WEST SUSSEX COUNTY COUNCIL CONSULTATION

TO:	Arun District Council FAO: Hebe Smith
FROM:	Highways, WSCC
DATE:	29/09/2026
LOCATION:	Flintacre, Toddington Lane, Littlehampton, BN17 7PN
SUBJECT:	LU/174/26/PL Erection of a detached dwelling with open carport. This application affects the setting of listed buildings, is in CIL Zone 2 and is CIL Liable as a new dwelling.
DATE OF SITE VISIT:	N/A
RECOMMENDATION:	Advice

Drawing Title
Proposed Site layout Plan, Front Elevation, Side Elevations and Rear Elevation.

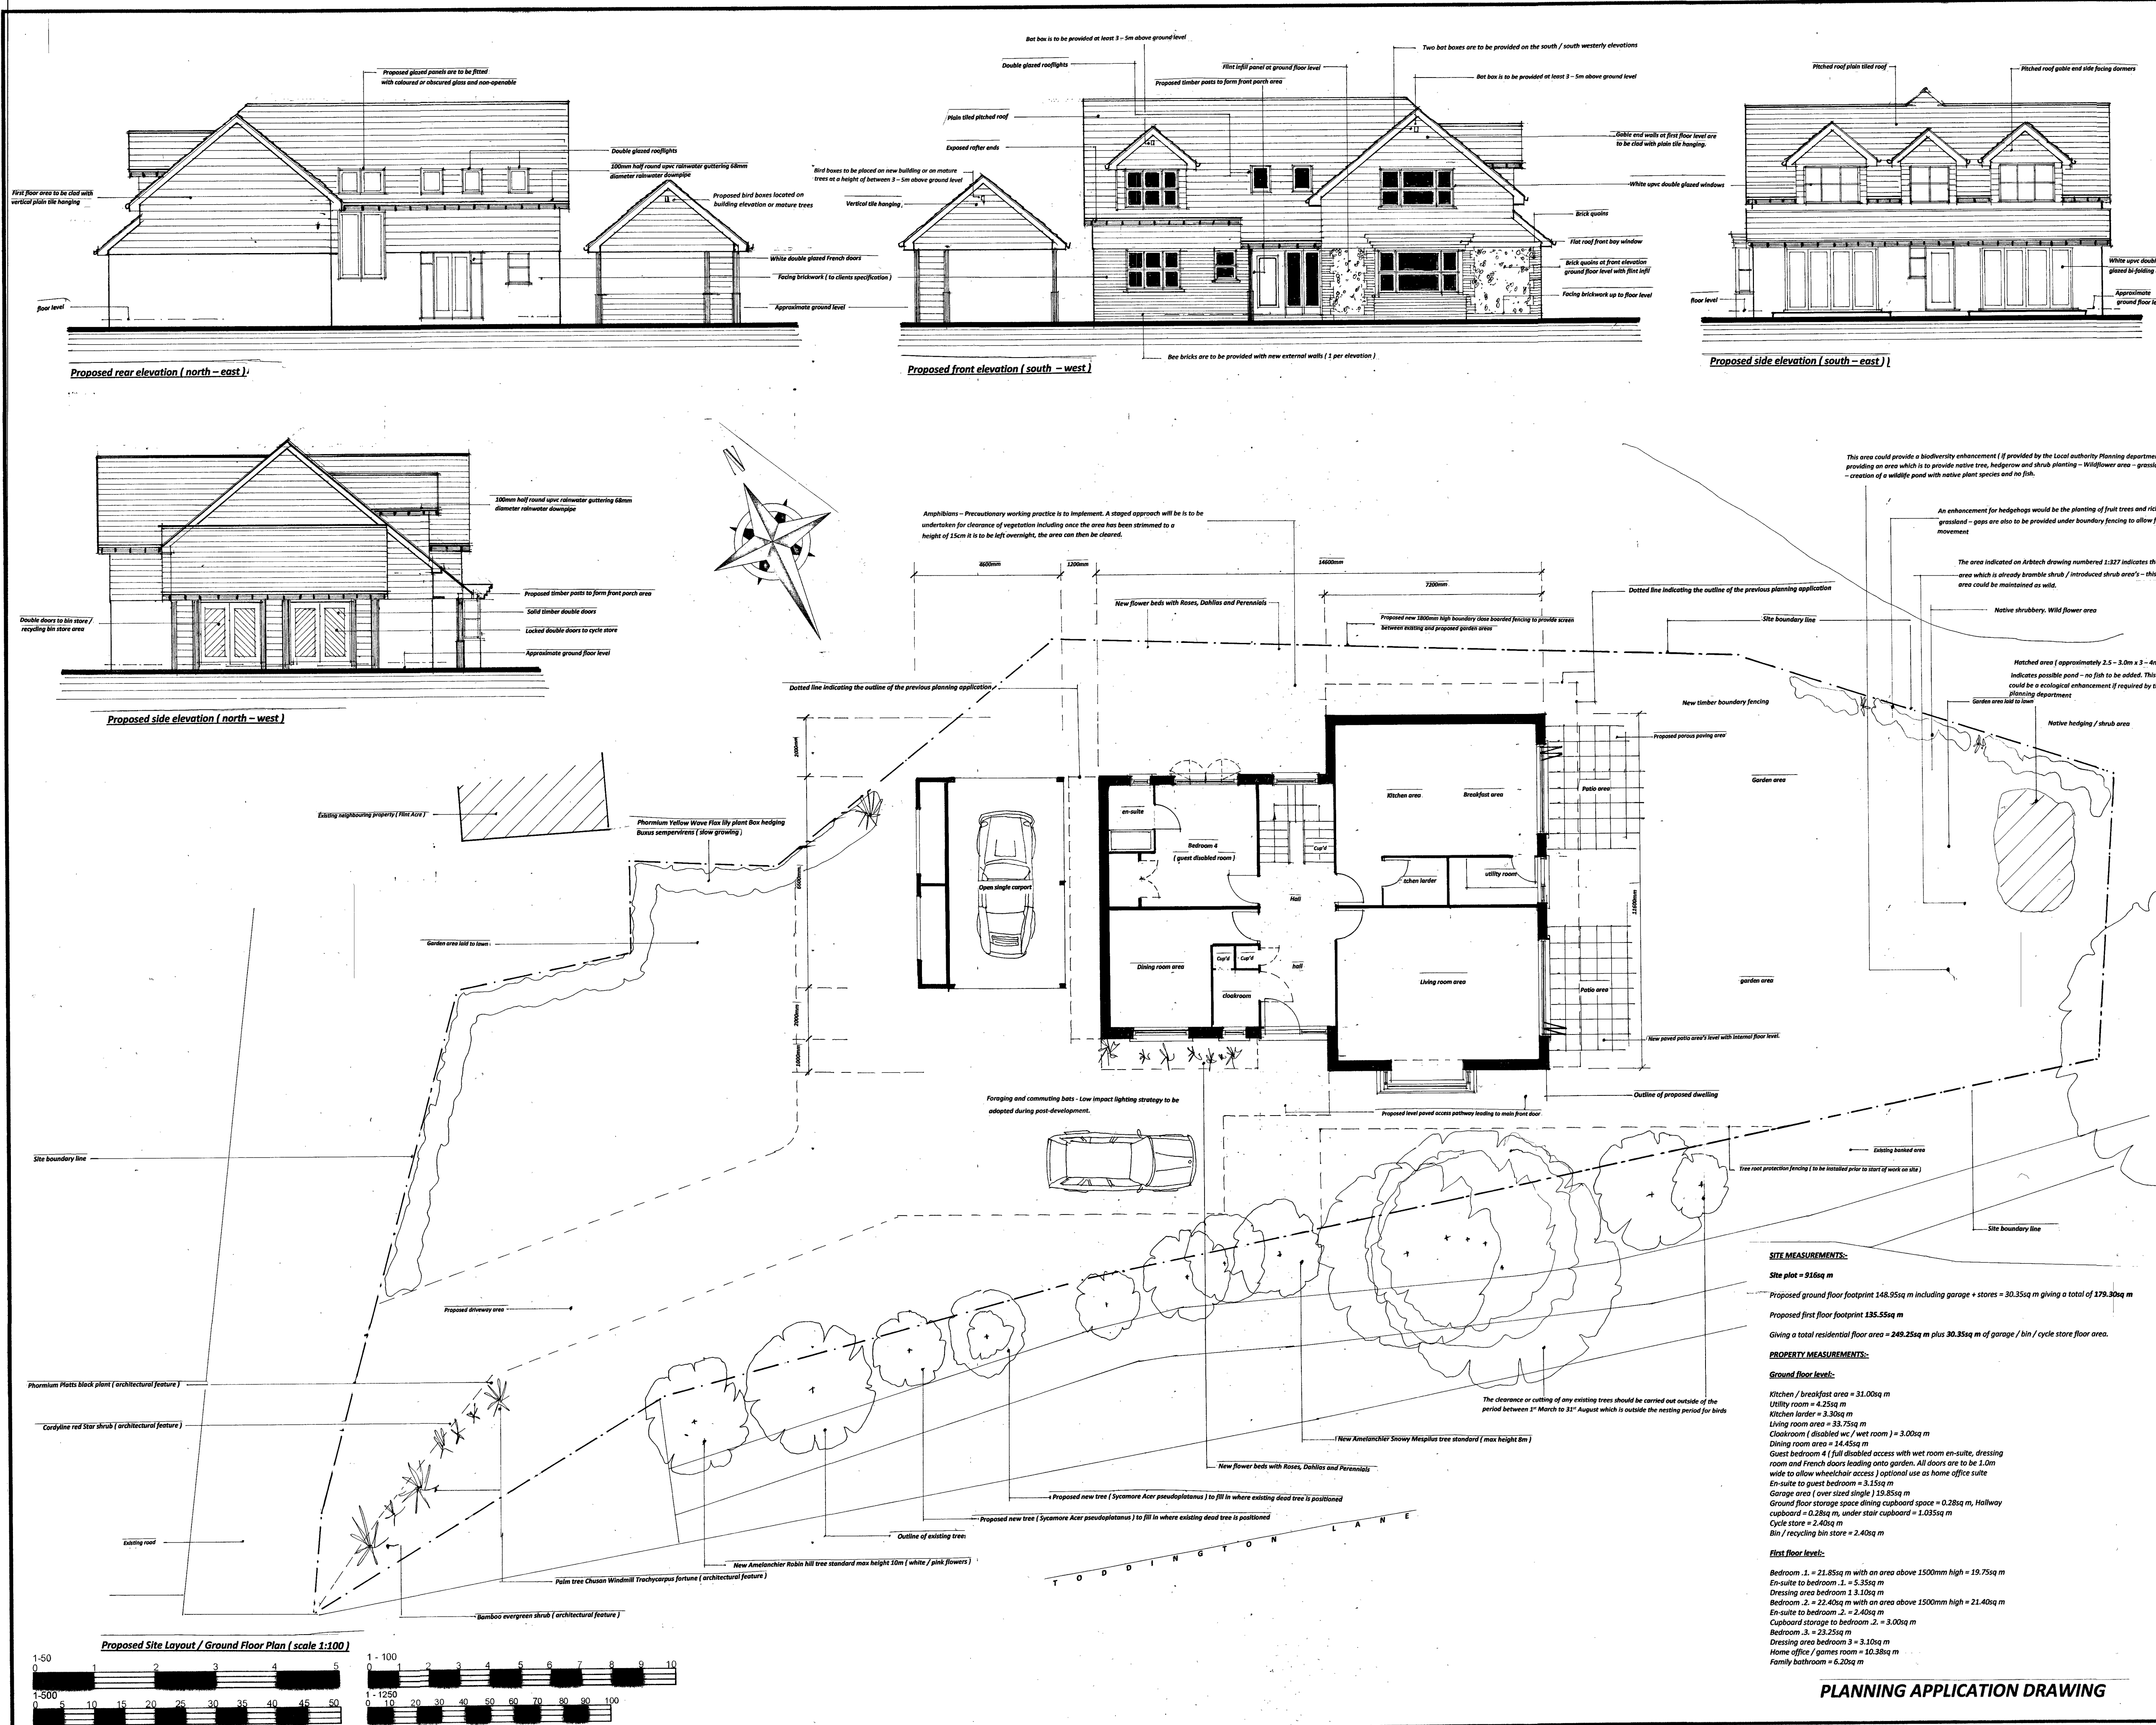
Regarding parking, under Arun Parking Standards, the LHA would expect a dwelling of this size in this location to provide at least three car parking spaces. From inspection of the plans, there is sufficient space within the proposed driveway and carport to accommodate this parking requirement. In addition, the site exhibits suitable space for on-site turning to be achievable, allowing cars to turn and exit the site in a forward gear.

The site is situated in a location within walking/cycle distance of local services, such as shops and schools. Public transport connections are within cycle distance of the site, with Littlehampton Train Station situated approximately 2.3km south of the site. The nearest bus stops are situated on Lyminster Road and Worthing Road, both approximately 1km from the site. The LHA would request that details of secure and covered cycle parking provision be provided, to promote sustainable travel.

No part of the development shall be first occupied until the car parking has been constructed in accordance with the approved site plan. These spaces shall thereafter be retained at all times for their designated purpose.

No part of the development shall be first occupied until covered and secure cycle parking spaces have been provided in accordance with plans and details to be submitted to and approved by the Local Planning Authority.
